**Our Case Number:** ACP-324033-26

**Re:** Proposed development of a soil recovery facility  
in the townland Kilmartin, Coyne's Cross, Co. Wicklow

Your Ref: **ACP-324033-26**  
Our Ref: **SID-WW-2026-002**

**Proposed Strategic Infrastructure Development (SID): Kilmartin Junction 14 Limited: to establish and operate a soil recovery facility: Kilmartin townland, Coyne's Cross, Co. Wicklow.**

Figure 6-9 - Watercourses in the vicinity of the Site

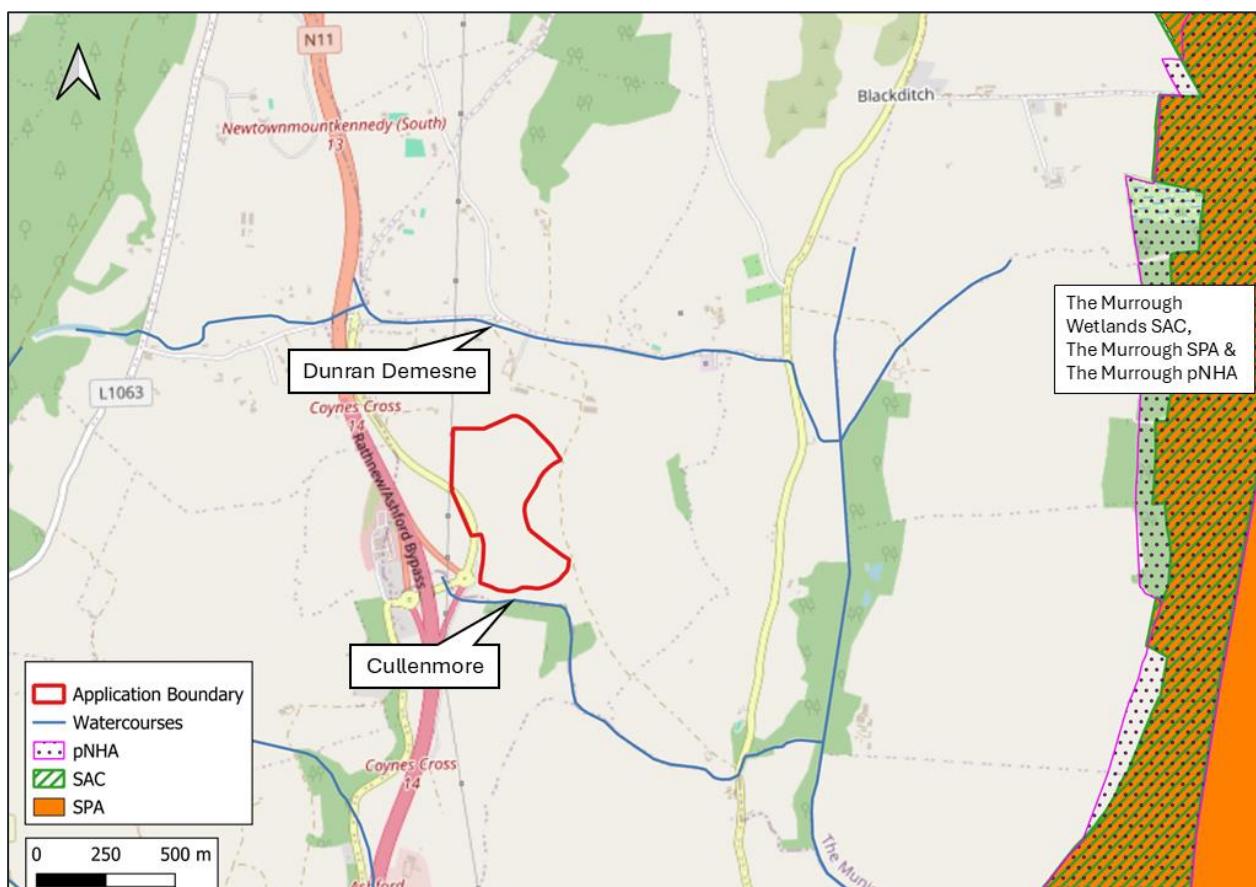
The proposed development is located 45m north of the Cullenmore Stream, which flows approximately 2.7km downstream before discharging into The Murrough SPA and The Murrough Wetlands SAC. The Inchanappa River/Coynes Cross Stream is also located 300m north of the site, joining to the Cullenmore Stream upstream of the SAC and SPA. The site has a central valley that slopes from north to south, with run-off from the southern part draining to the Cullenmore Stream, and from the north draining to the Coynes Cross Stream, according to Chapter 8 Water of the EIAR. According to the Water Chapter the site is located in an area of "*moderate – high groundwater vulnerability in the eastern half of the Site where there is superficial deposit cover of Till, and extreme or 'rock at or near surface' in the west where superficial cover is mapped as being less or absent (EPA, 2022a).*" The site also

There has been no assessment completed on the potential for groundwater impacts within the AA Screening Report, and although surface water impacts are discussed, the Department does not consider the assessment sufficient to rule out potential downstream impacts on the SAC and the SPA. Section 8.5.6 of the Water Chapter discusses Designated Sites and notes: *“The habitats that are dependent upon freshwater [within the SAC and SPA] are likely to be supported to some extent by input from the surface watercourses that pass the Proposed Development and feed into other watercourses that flow into/through the SAC”*. However, the AA Screening rules out potential downstream impacts on European site *“Considering the inert nature of the proposed fill material and considering the actual distance between the application boundary and the watercourse, the ingress of contaminants is considered unlikely. In this context, the Zol for surface water contamination is restricted to within the application boundary”*. Section 4.4 and Table 4-2 also note that there is *“no hydrological connectivity”* between the proposed development site and the Murrough Wetlands SAC and SPA. The AA Screening and Water Chapter note that in the centre of the site, where the elevation is at its lowest, run-off accumulates and forms an area of wet ground in the winter. The Water Chapter also notes *“it is assumed that the local surface watercourses are fed by a combination of surface water run-off and some baseflow from groundwater”*. Therefore, during periods of wet weather, surface and groundwater from the lands are likely directly feeding into downstream water features.

The release of contaminated surface water runoff and/or an accidental spillage or pollution event into any surface or ground water features during the proposed works/operation has the potential to affect water quality in the receiving aquatic environment. Such a pollution event may include: the release of sediment into receiving waters and the subsequent increase in mobilised suspended solids; and the accidental spillage and/or leaks of contaminants (e.g. fuel, oils, lubricants, paints, bituminous coatings, preservatives, weed killer, lime and concrete) into receiving waters. Given the number of vehicles movements, a wheel wash, access roads, welfare facilities (including for wastewater), and construction materials required for the development of the site, a specific hydrological and hydrogeological assessment on the potential for potential impacts on the downstream European sites must be completed, using a conceptual site model. This should illustrate the source-pathway-receptor relationships that may exist between the proposed development site and downstream European sites.

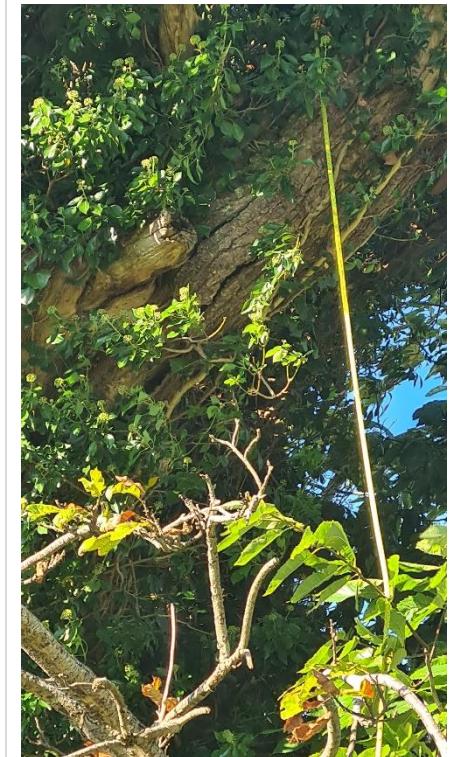
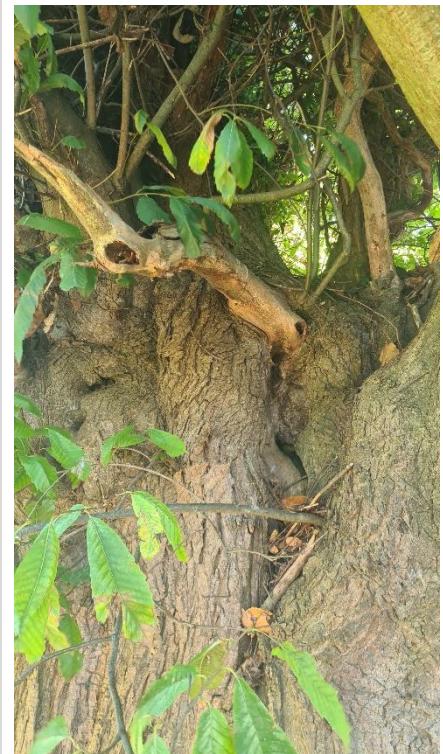
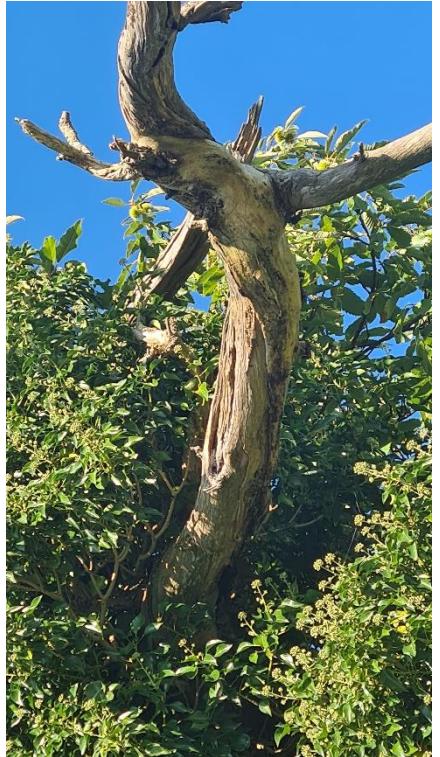
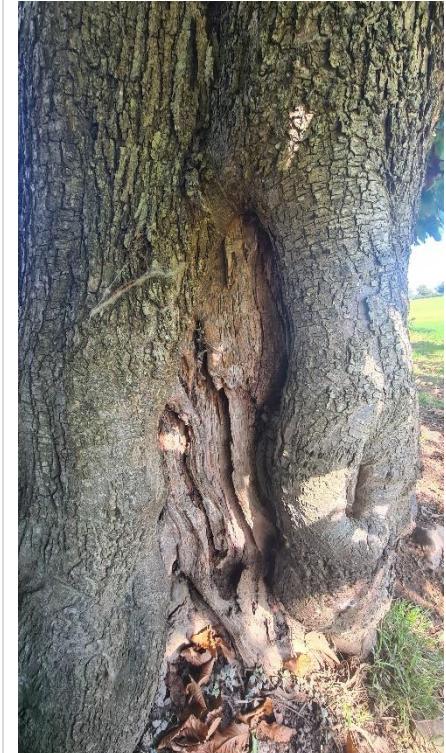
The Department notes that daytime inspections for potential bat roosting features were carried out within the proposed development site, with a number of trees climbed to further inspect potential roosting features. Whilst no roosting bats were identified, one sweet chestnut tree was considered to have 'high' suitability for roosting bats, and another two trees were considered to have 'moderate' bat roosting potential (as per Collins, 2016). The Department wishes to advise the applicant of an update to the Collins 2016 guidance, which was published in 2023 and should be referenced and adhered to in relation to the classification of potential bat roosts. No activity surveys of these trees or of potential commuting/foraging habitat within the site were carried out. According to 6.11.4.1 of the Biodiversity Chapter, as surveys to confirm presence/absence of roosting bats were not undertaken "*in line with the precautionary principle, it is assumed that the identified potential roosts are indeed occupied by roosting bats*". Therefore, considering this, a derogation licence should have been applied for to this Department. Any roosts identified are protected under the provisions of Regulation 51 of the European Communities (Birds and Natural Habitats) Regulations 2011-2021. Damage to such roosts can only occur if a derogation licence under Regulation 54 is obtained. In particular, the judgement of the European Court of Justice Hellfire Massey Judgement should be consulted.<sup>5</sup> That decision specifies that where a derogation licence is necessary, it must be obtained in advance of a grant of planning permission.

The Biodiversity Chapter recommends a number of mitigation measures to for the loss of roosting habitat and injury/death of roosting bats, including the provision of activity surveys to determine presence/absence of roosting bats. This should have been completed prior to the planning submission, and it is not sufficient to recommend surveys post planning permission (should permission be granted) when surveys to determine the baseline of the site were not carried out. A detailed mitigation strategy for the protection of bats is required, which should be included in the derogation licence application. The Department therefore recommends bat activity surveys are carried out on these trees with potential roosting features and submitted as further information. Even if roosting bats are not identified, bats can occupy roosting features at any stage prior to tree-felling, and therefore mitigation measures must include pre-felling surveys immediately prior to removal. The provision of additional roosts such as bat boxes is recommended, and the mitigation strategy should include the details of this, including; the proposed locations of deployment, a detailed monitoring strategy over a number of years, and the type/quantity of boxes.
